Our Case Number: ACP-324383-26

Re: Proposed IDA Belview Infrastructure Development
Belview, Slieverue, County Kilkenny

SID Online Observation

Title: **Proposed Access Road Layout Sheet 1 of 2**

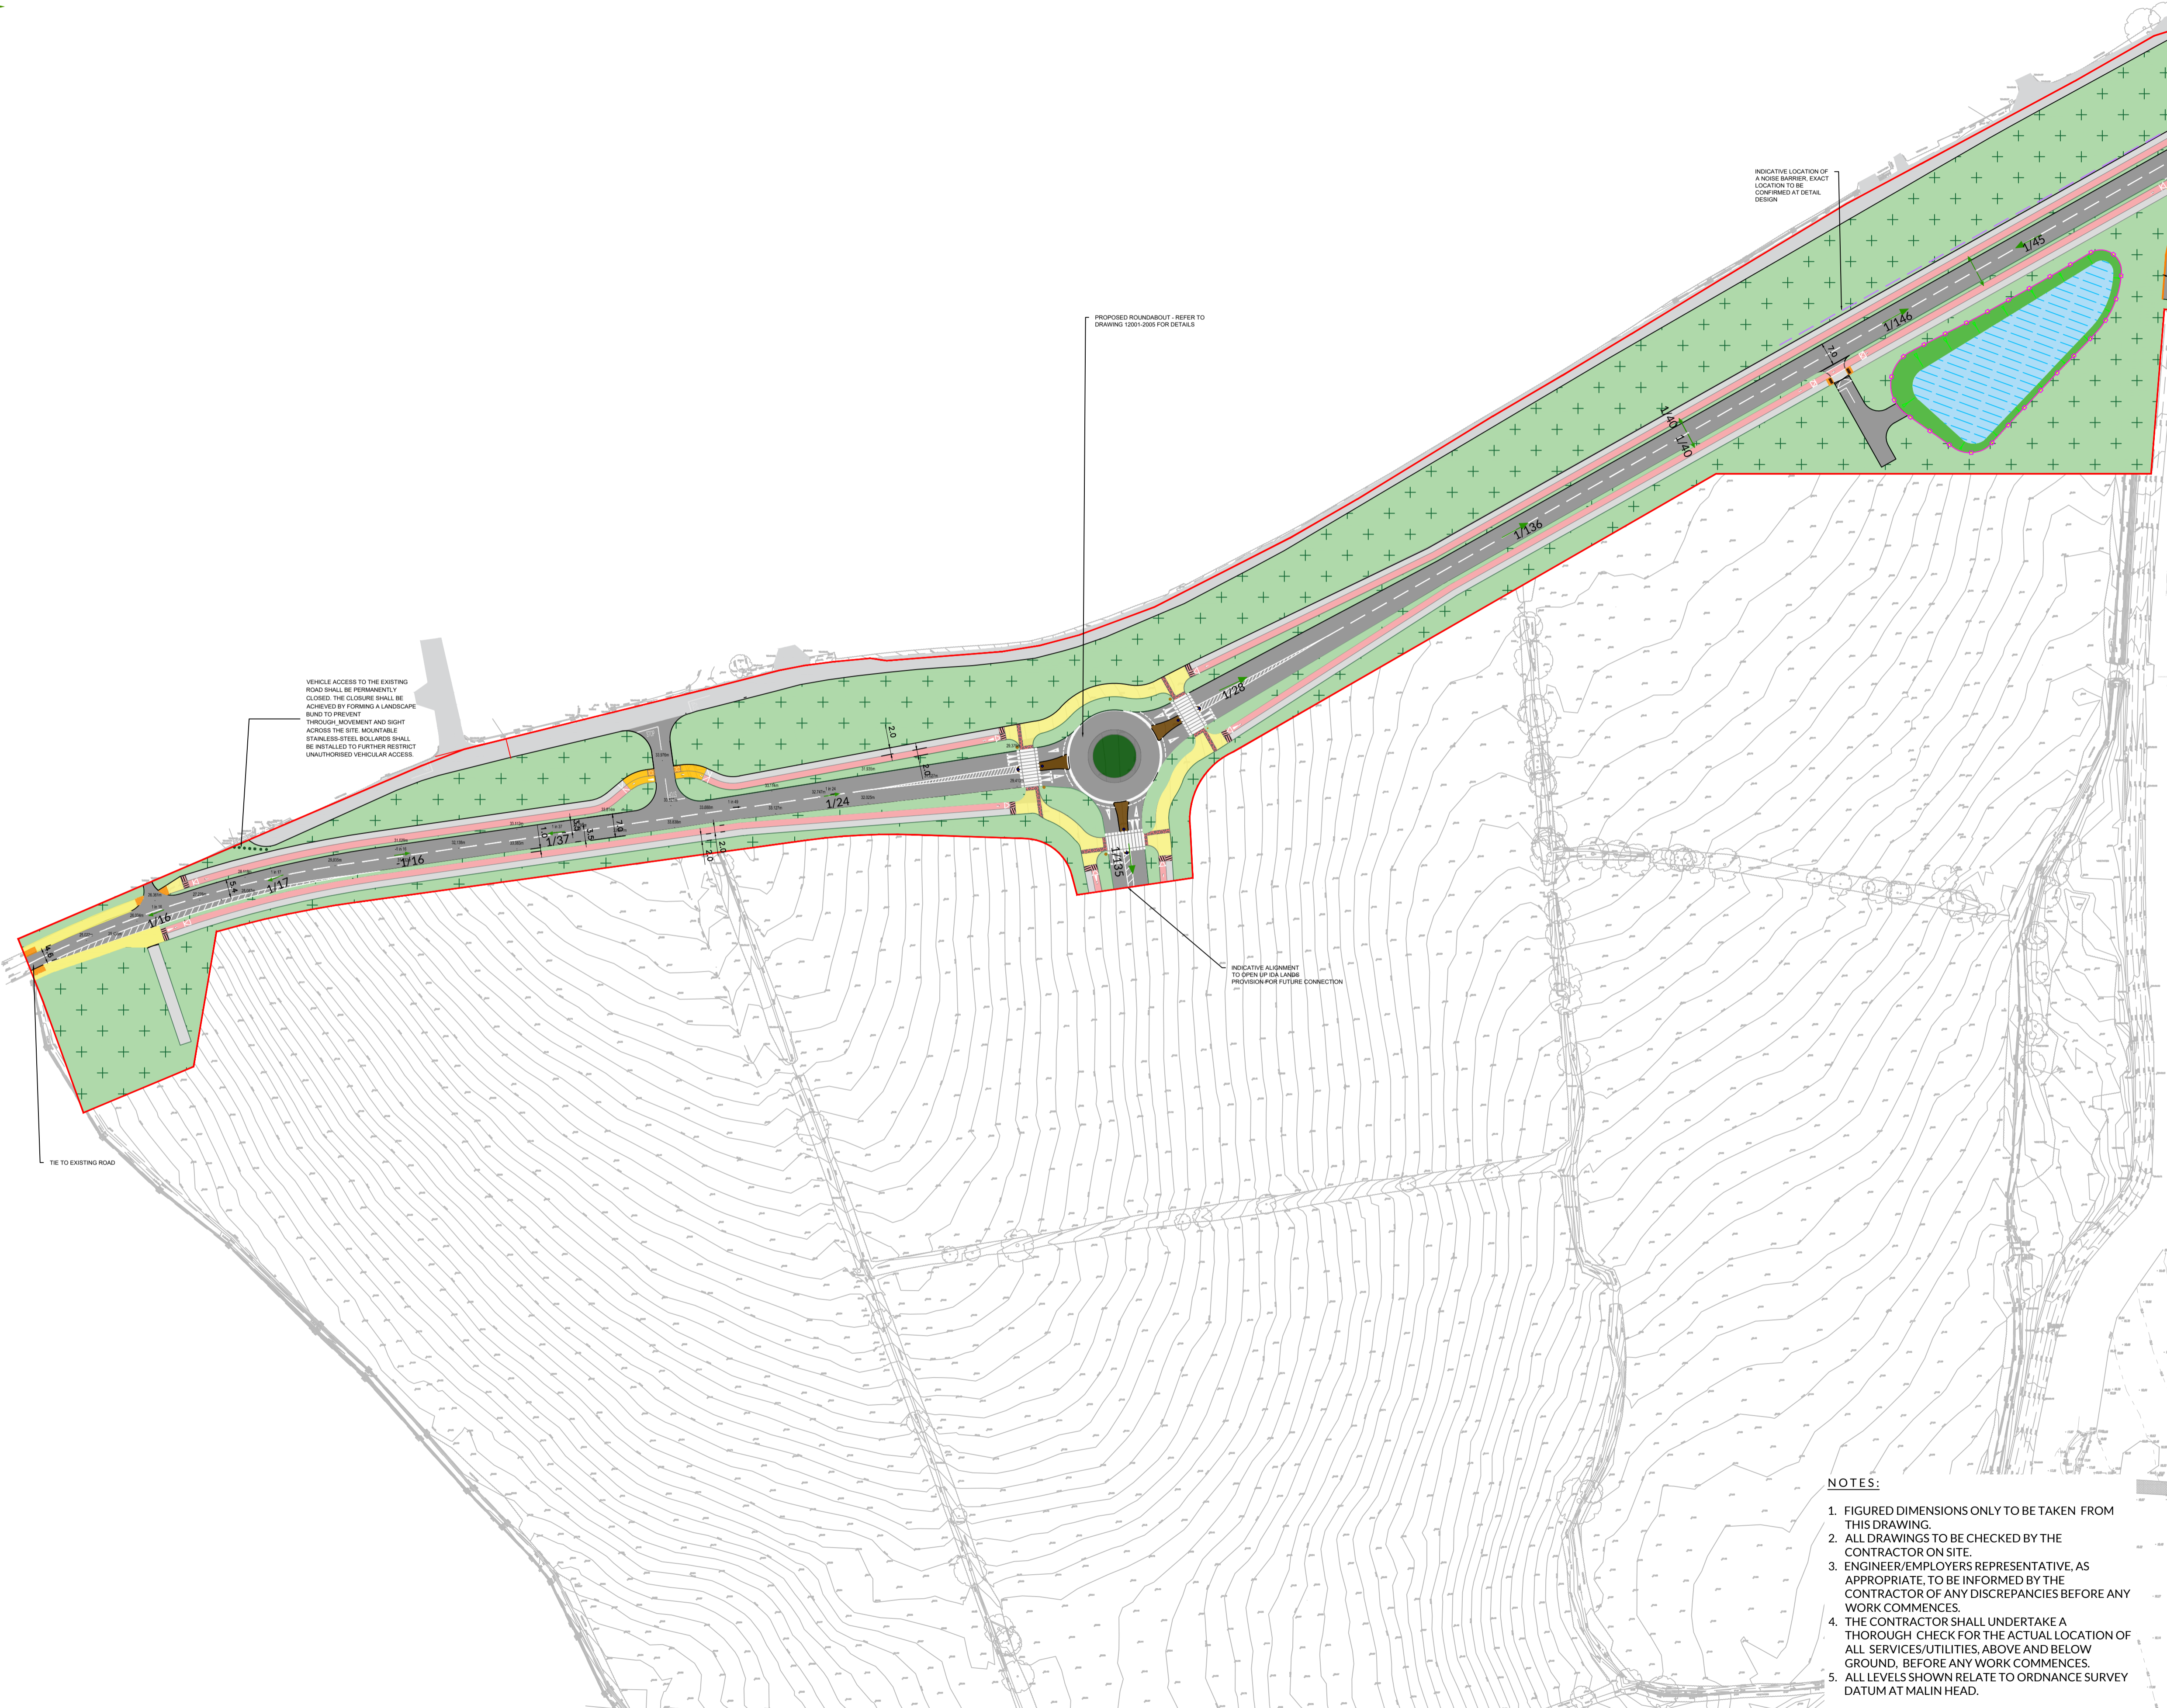
I live on Kilmurry lane (X91 KXW0) and although the development doesn't directly affect me, it seriously affects my parents house (X91 X8Y2). I am very concerned for their safety if this development goes ahead. When they exit their gate they will be driving onto a much wider road with the possibility of vehicles travelling at a higher speed. As they are both in their mid eighties, I would fear that the proposed road layout would make them nervous of driving.

A more serious concern is the fact that their house has been excluded from the proposed cul de sac. By doing this they will be isolated from their neighbours with whom they have close bonds. Obviously it would be far more favourable and safer for their house to be included in the cul de sac, especially into the future when the road outside their gate (L3412) will be further developed and widened.

Another implication for my parents will be the noise. As the proposed road will be joining the existing road (L3412) outside their house, there will be NO possibility of a noise barrier. Because the road alignment narrows at the entrance to their house, vehicles will be braking thus causing more noise.

There was NO noise receptor placed near my parents house (X91 X8Y2) or their neighbours house (X91 X8H1).
